ZONING DOCUMENTS

ADDRESS:
**17925 US HWY 24
PEYTON, CO 80831**

SHEET TITLE:
AERIAL MAP

SHEET NUMBER:
ZD-1

SHEET NUMBER:  
**ZD-1**

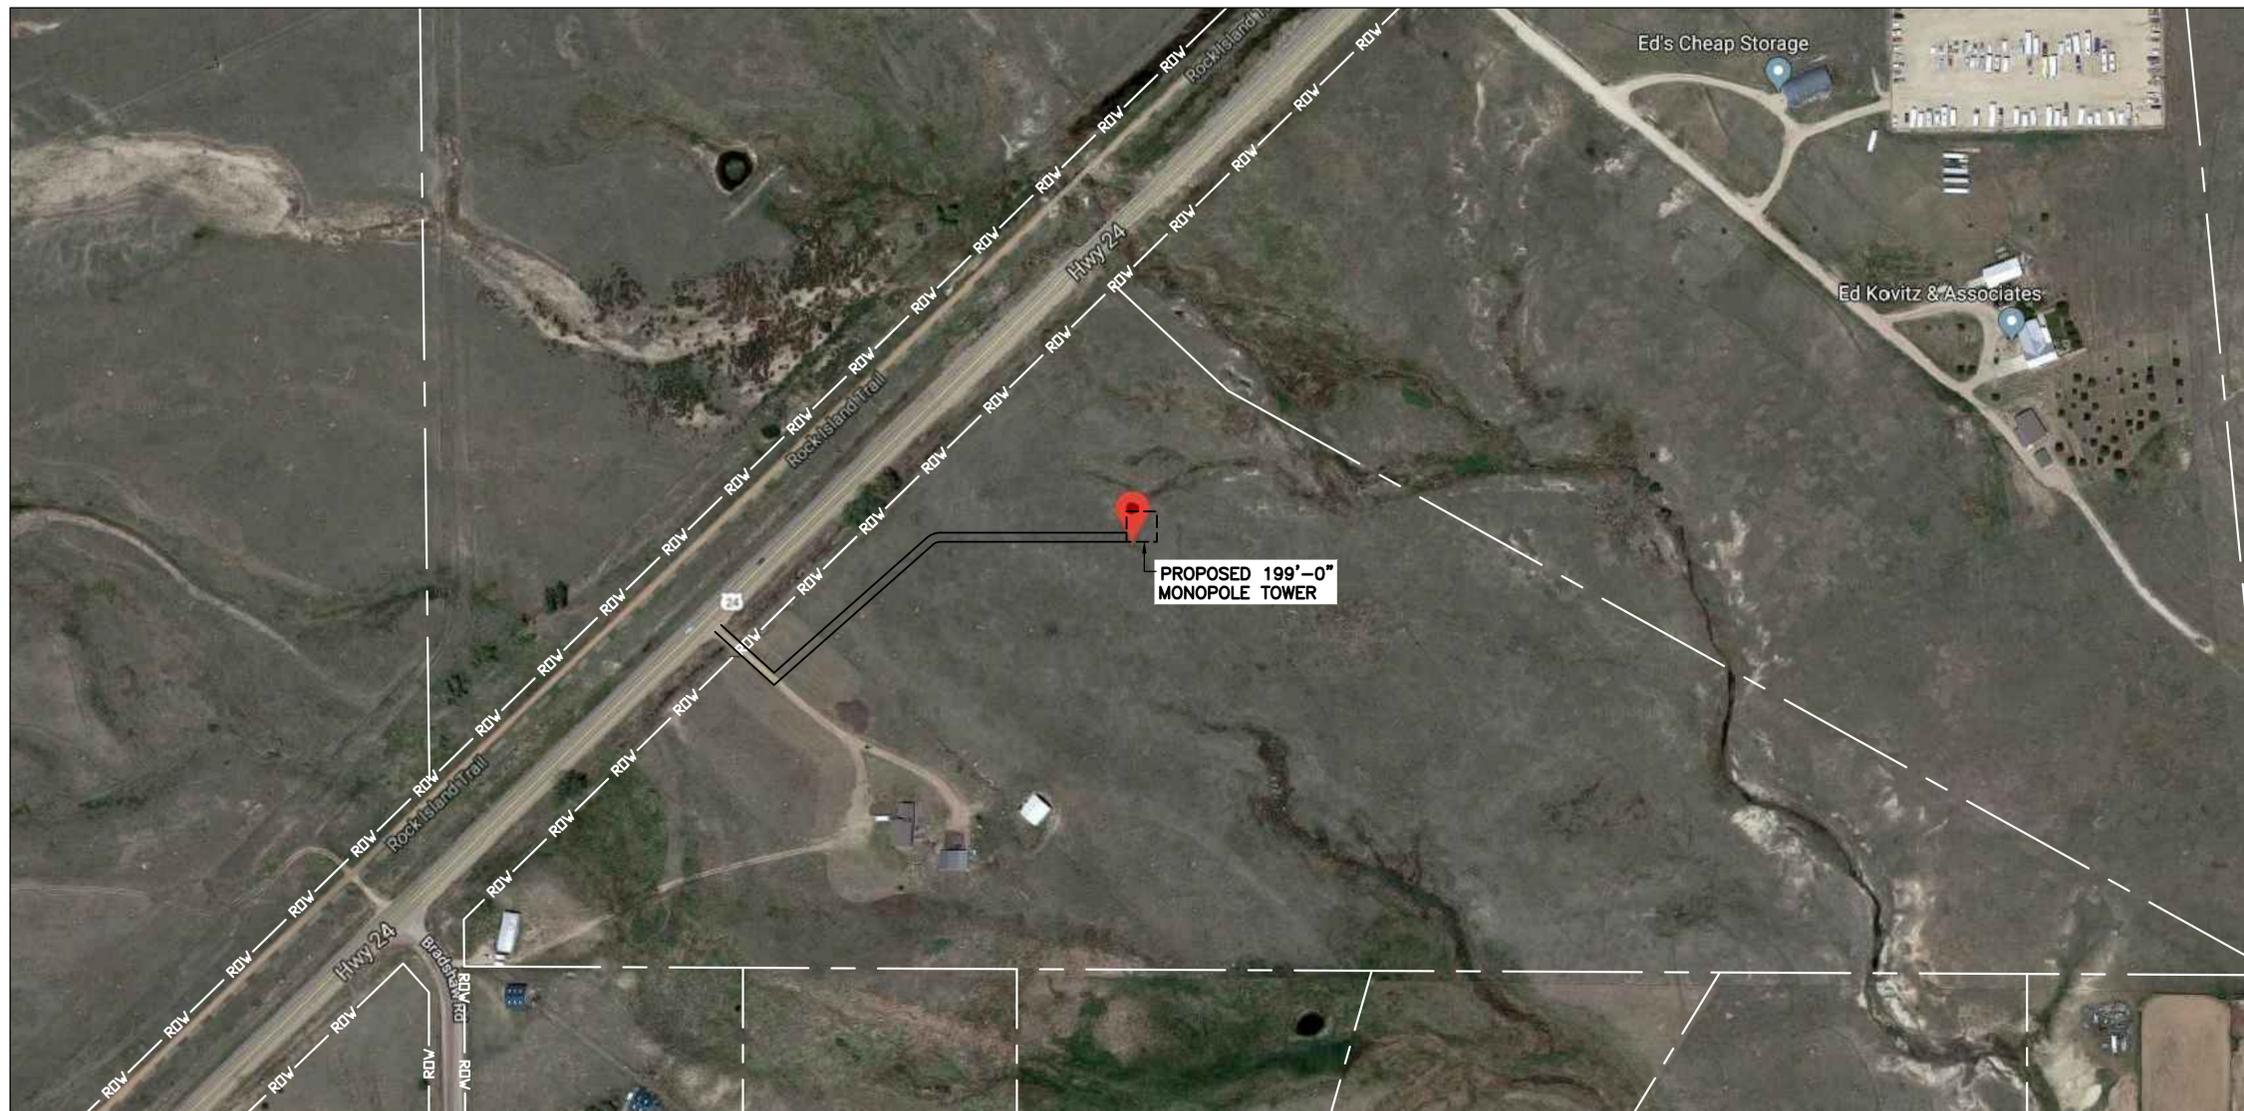
For vicinity maps, we prefer to have a larger area shown. Please zoom out further so we can see more of the general area.
